**KELLER SPRINGS LOFTS**  
 LOFT APARTMENTS IN ADDISON, TEXAS

**DOMESTIC BOOSTER PUMP SCHEDULE**

2 PUMP/RISER ROOM  
 SCALE: 1/4" = 1'-0"

FIRE PUMP ROOM PLAN VIEW
SCALE: NTS

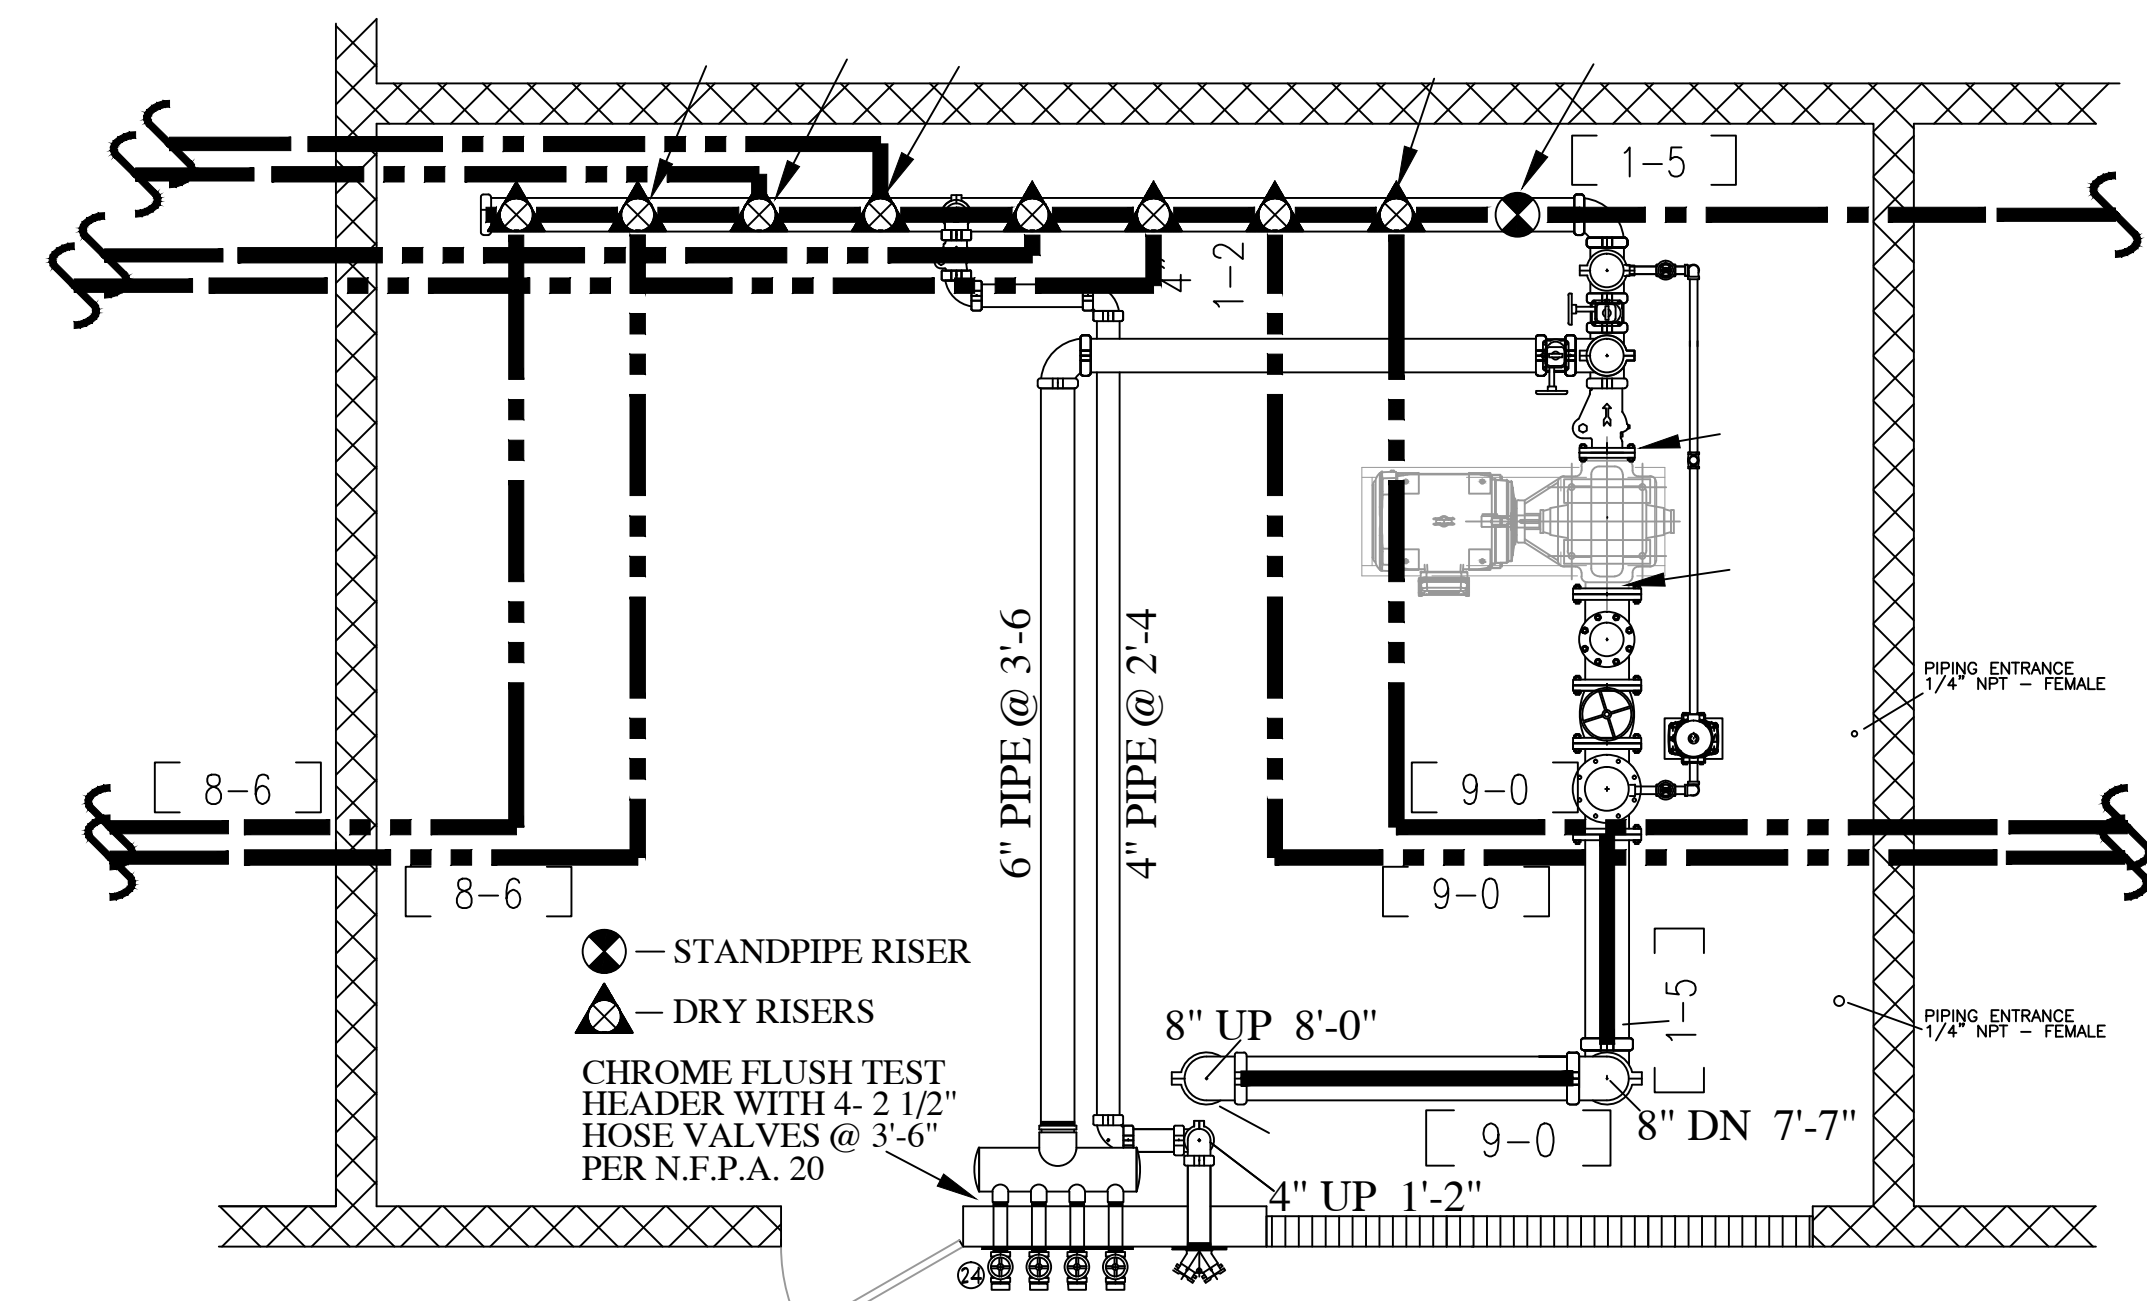
*WRONG = 21'-9" x 15'-6"  
 Correct = 24'-8" x 17'-10"*

*SEE 4/6.4 Arch. For Pump Room Dimensions  
 NOT TO SCALE*
